# CITY OF ALBUQUERQUE

August 26, 2019

**RE: Tierra Serena (Glendesto) Subdivision  
Release of Financial Guarantee  
Revised Grading Plan Stamp Date: 1/23/18  
Certification Dated: 8/14/19  
Hydrology File: B18D020**

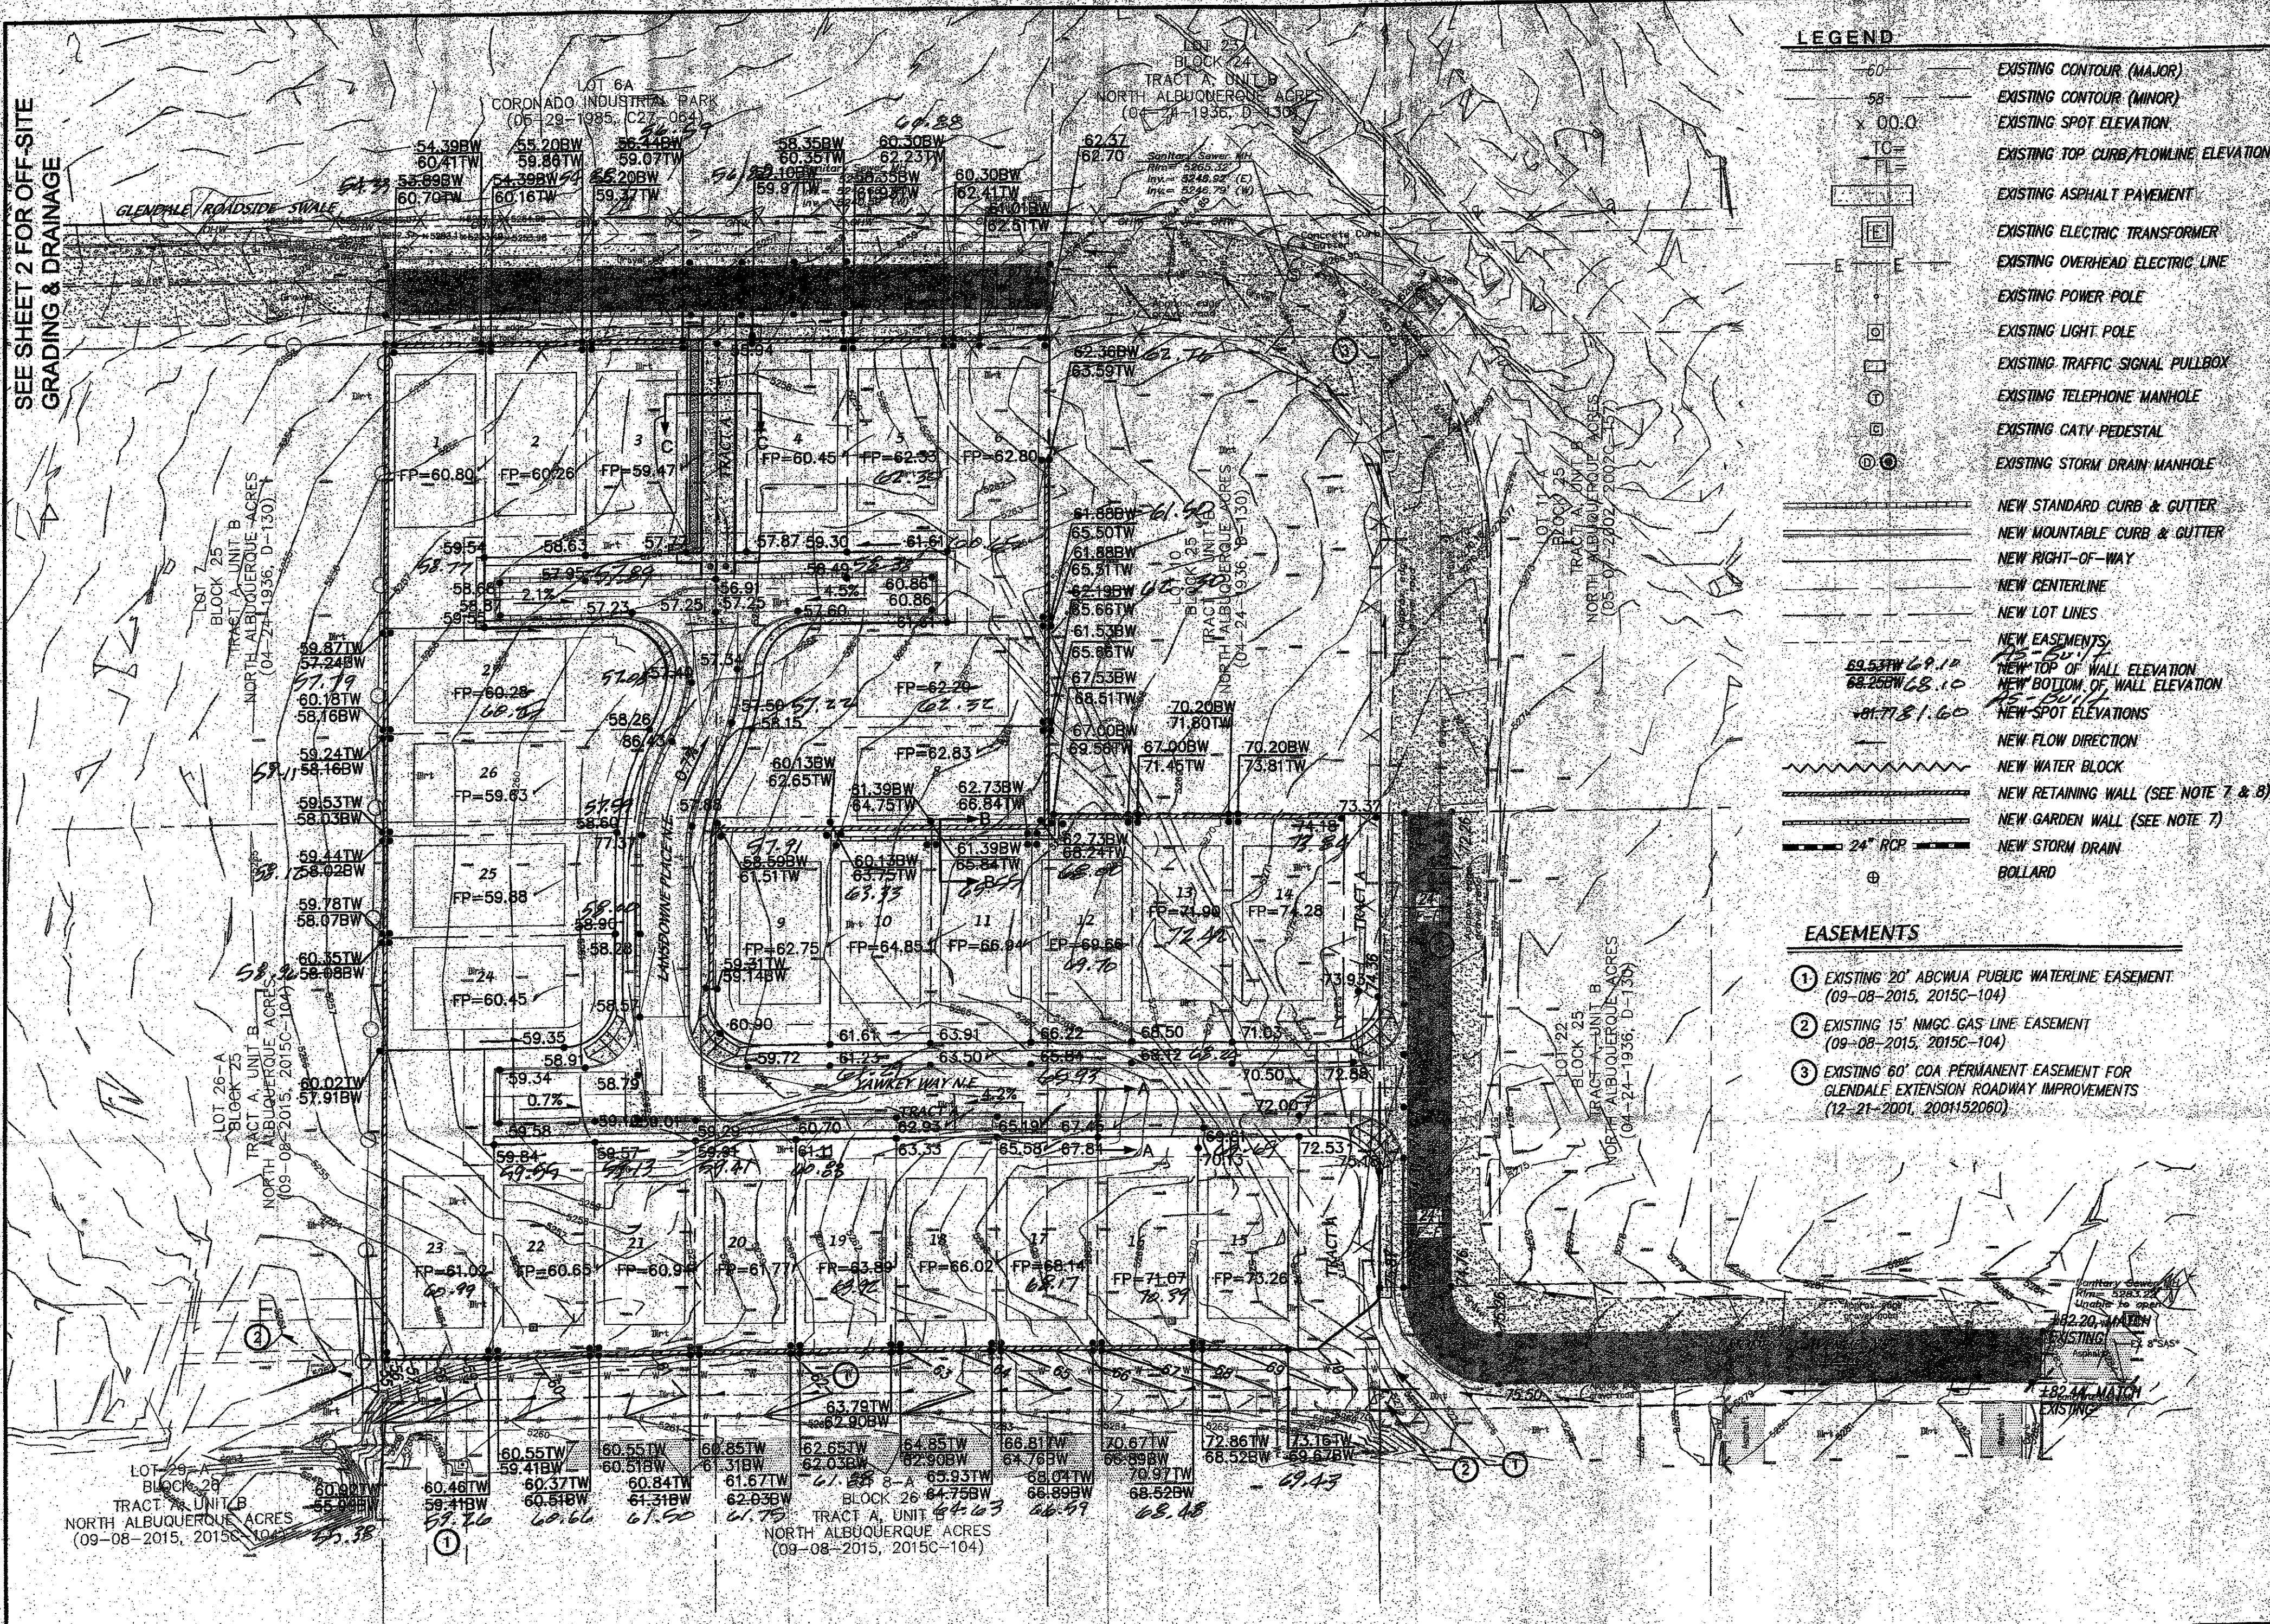
Prior to Lot 14 Pad Certification:

1. The parking lot needs to be removed prior to certifying Lot 14.
